From: Havis, Sean [REDACTED]
Sent: 13 January 2021 09:28
To: Simon Davis <Simon.Davis@arun.gov.uk>
Cc: Sparkes, Jessica [REDACTED]
Subject: RE: *EXTERNAL: Y/127/20/PL Standalone Application for the Access

Further to the below, I am afraid that my report has not been accepted at this time.

There is a concern that the access arrangements make no provision for cyclists to cross Main Road at the point where the cycle/footpath meets the highway (this point being directly opposite the vehicular access to the Bonhams Field site).

Drawing Title
SECTION 278
GENERAL ARRANGEMENT
AND PROPOSED
LEVELS PLAN

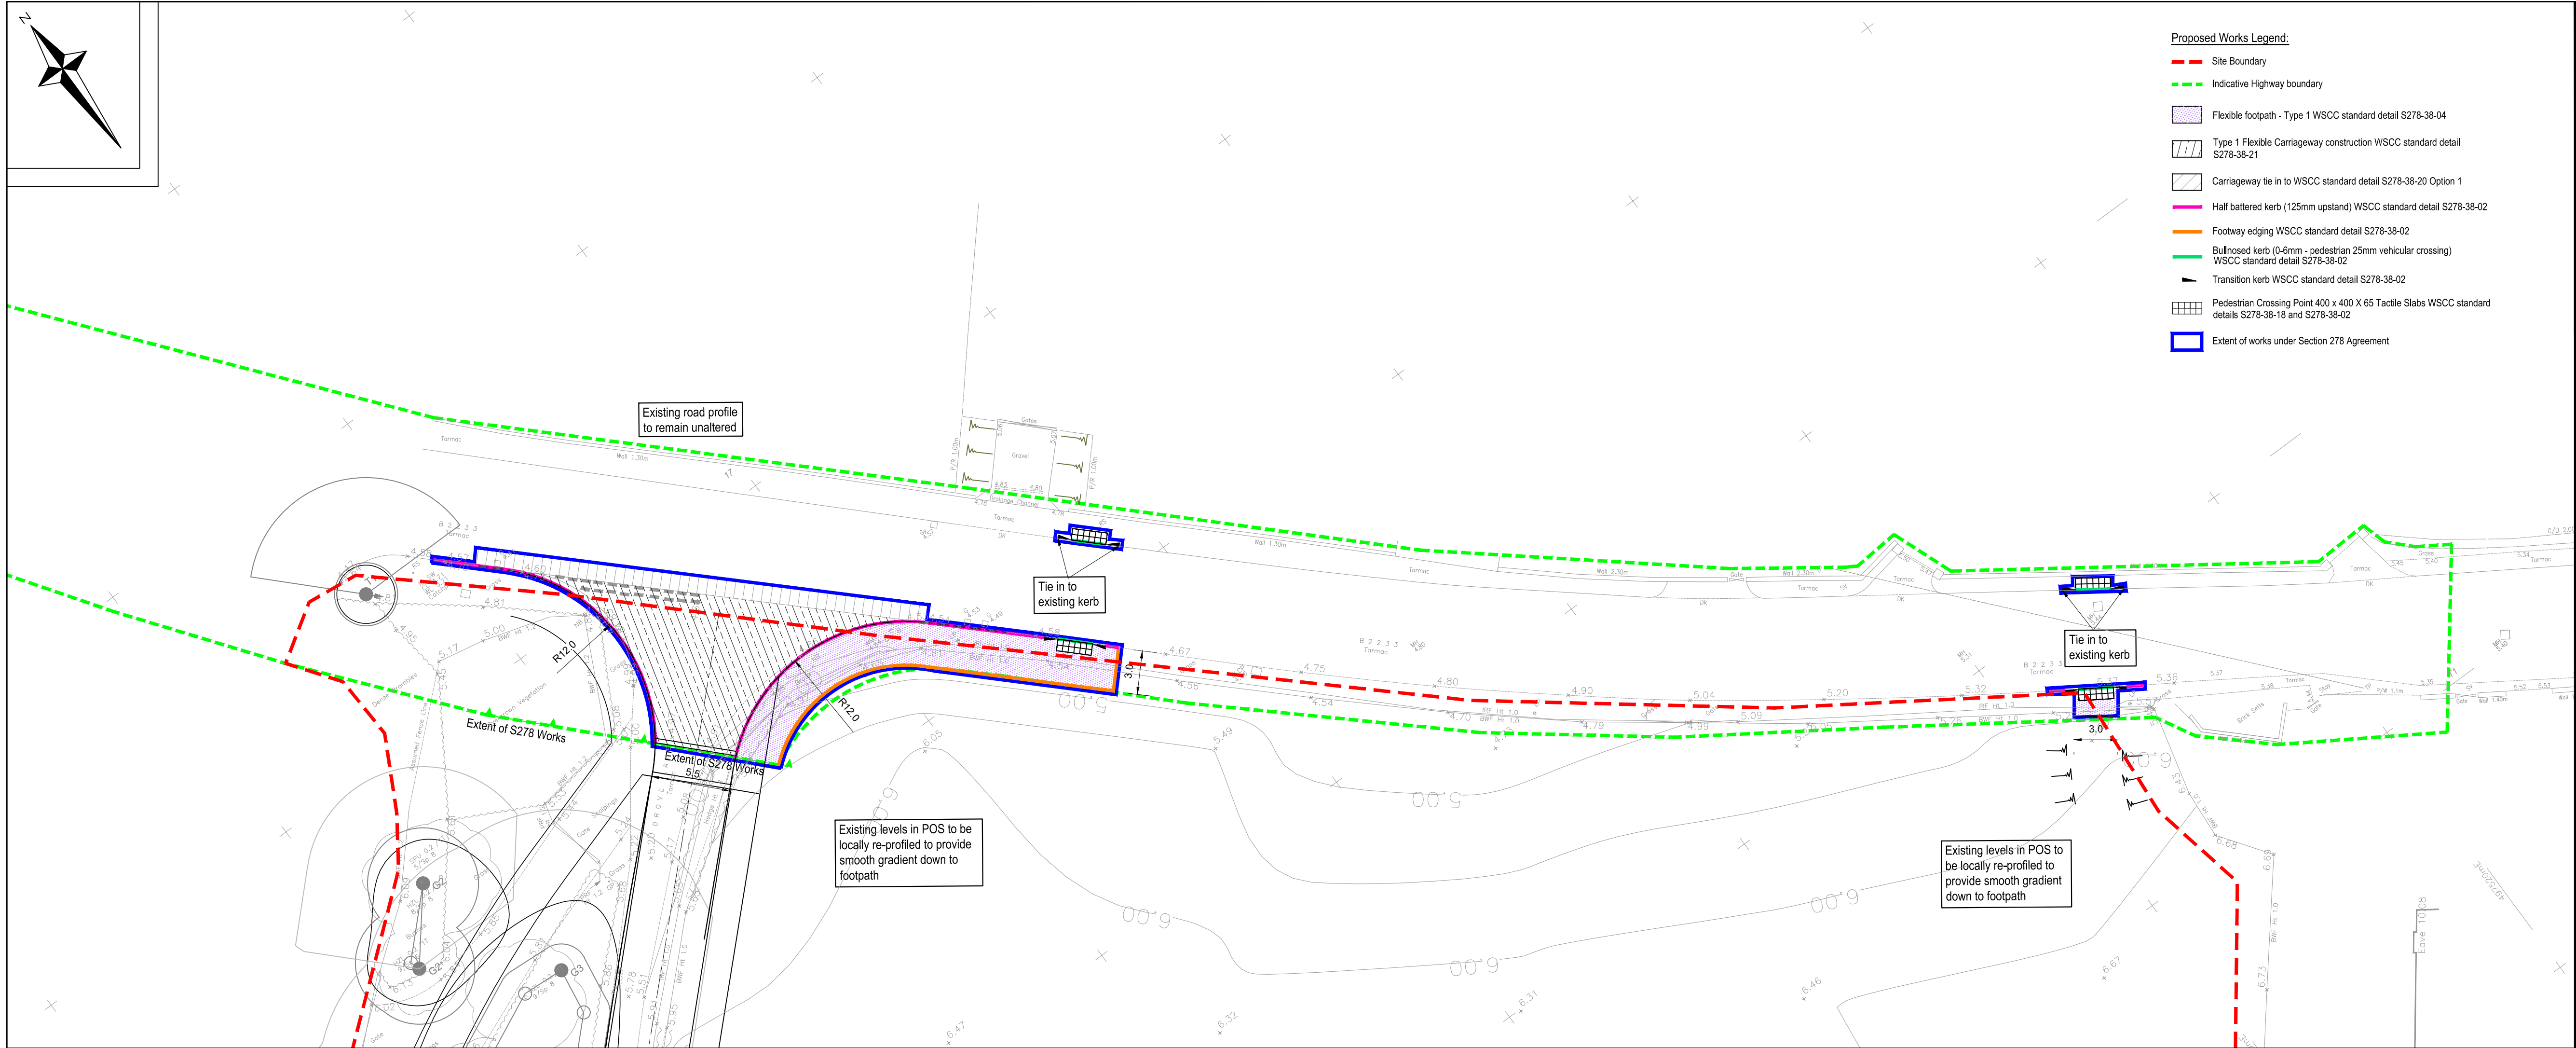
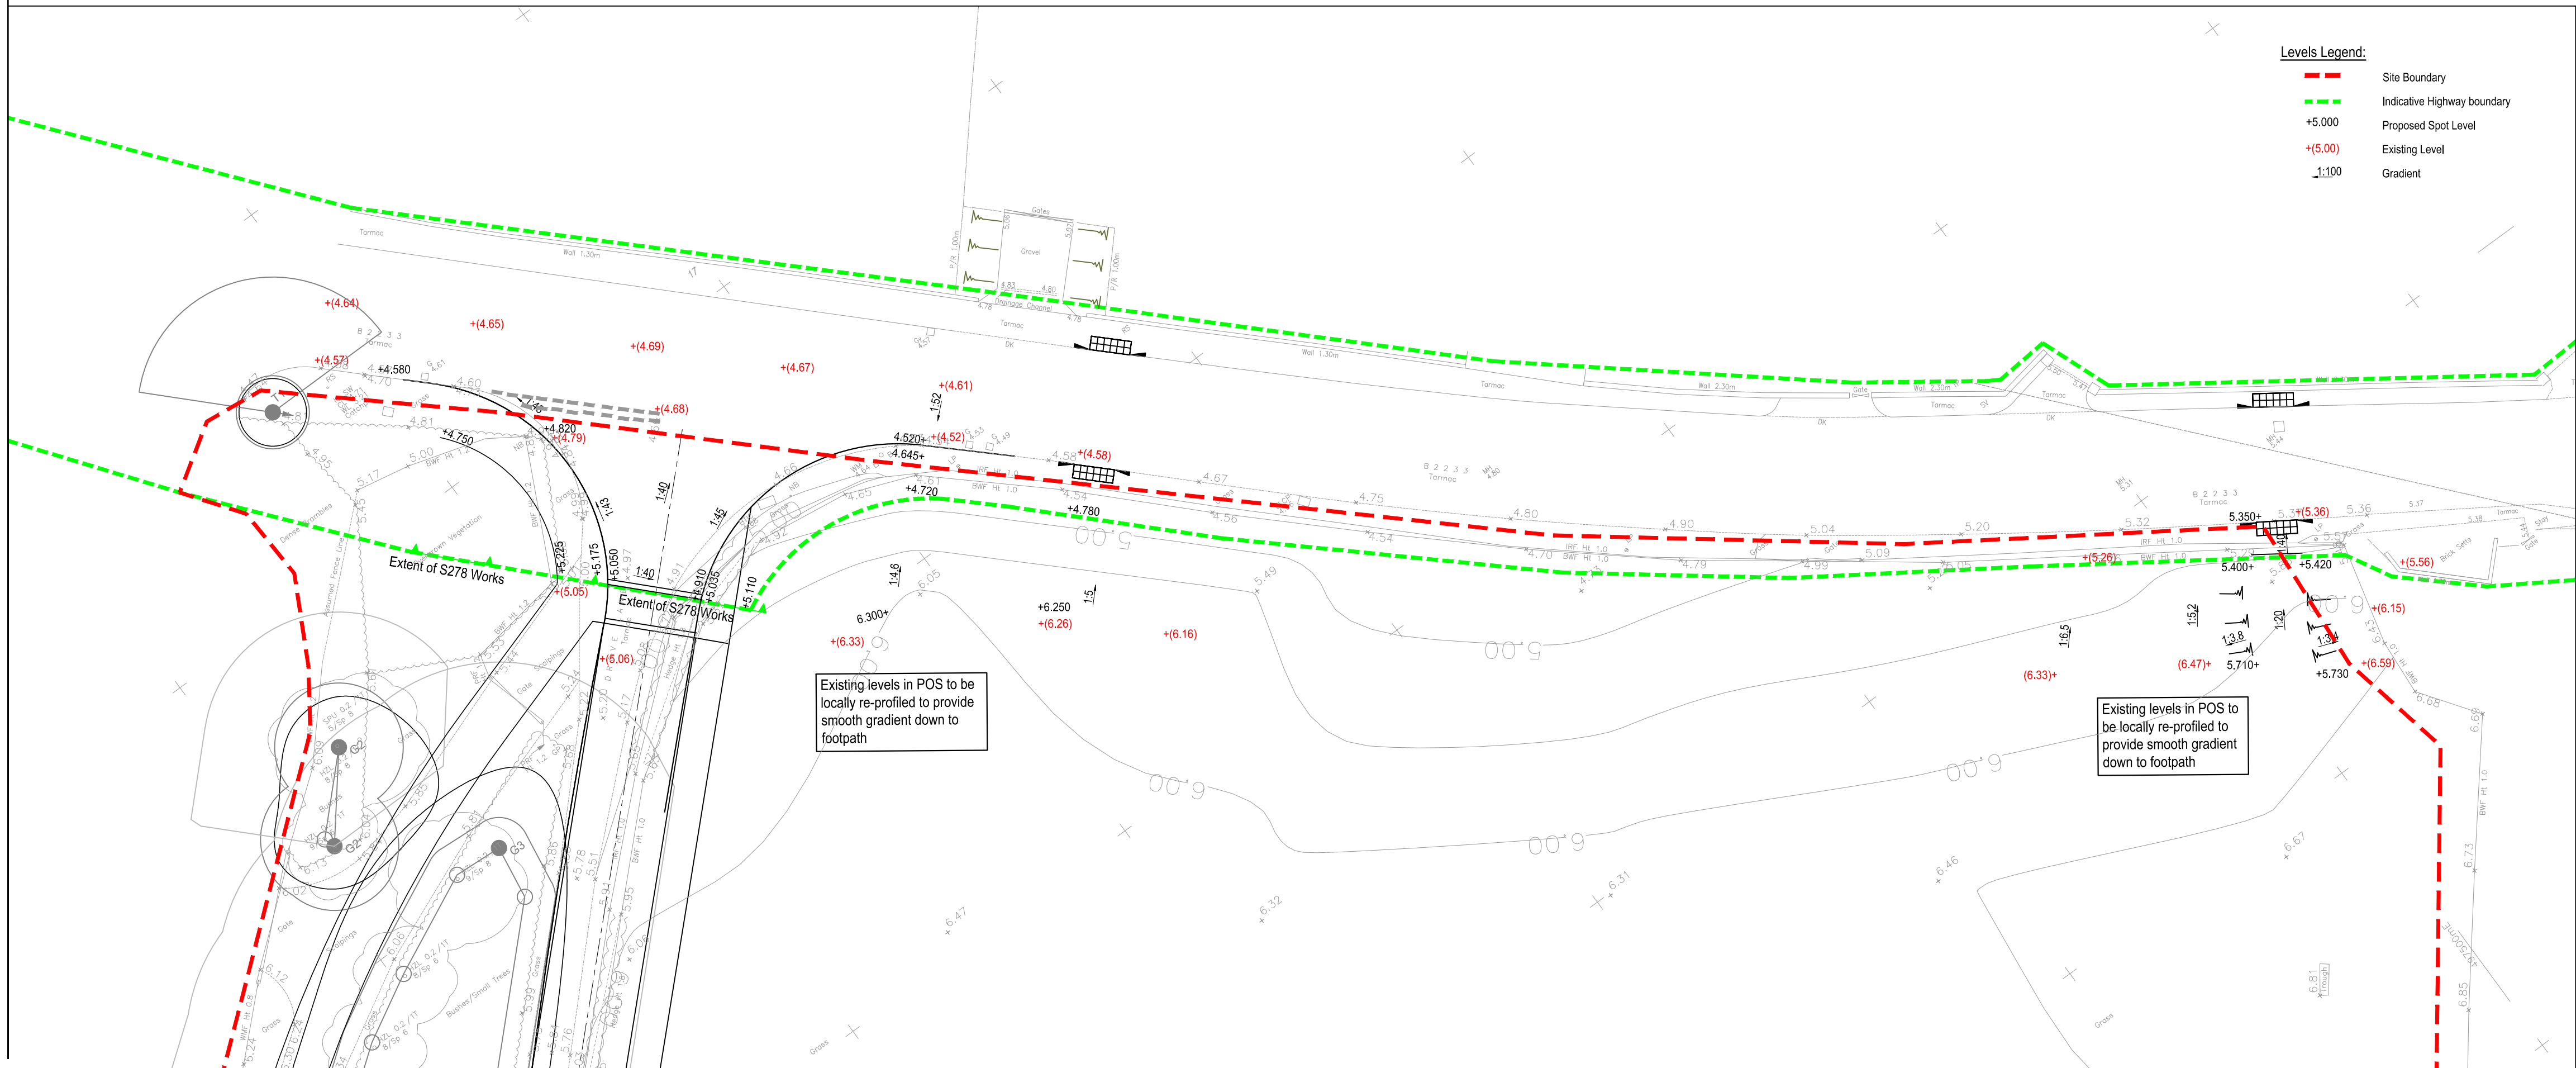
My feeling was that cyclists could safely cross the road by heading south at the end of the cycle path, crossing over Drove Lane and then using the tactile paved crossing point to cross over onto the pavement on the eastern side of Main Road. However, there is concern that cyclists, particularly children, will not do this and may instead just try to cross over straight into the Bonhams access with a risk of accident.

Pages 24-25 of the West Sussex Cycling Design guide does address the issue of the interface between the carriageway and a cycle path. It states that cyclists should not have to dismount to cross roads and that barriers should only be provided where there is a need and it recommends that a single bollard is sufficient.

Is there a reason why you have deviated from the alignment of the cycle path as shown on the outline access plan? This previously showed the cycle path meeting the carriageway with two bollards (attached for ease). That arrangement would still have been opposite the Bonhams access but does better meet the Cycling Design guidance.

The proposed access has been designed in discussion with WSCC and has received technical approval. Due to the access that will be constructed opposite to serve a different development, a crossing point could not be provided due to conflict of junctions. Instead we are proposing to direct cyclists on to the B2233 with appropriate warning signage and dropped kerbs. This has been through the technical approval process and in consultation with the Road Safety Audit process, all of which is now technically approved.

I hope that is satisfactory in explaining why the plan has deviated from the outline application and also confirms that it has been designed alongside WSCC and meets all the necessary technical approvals and safety audits.

It is our intention to supersede the approved plan via a Section-73 application once this application is decided.
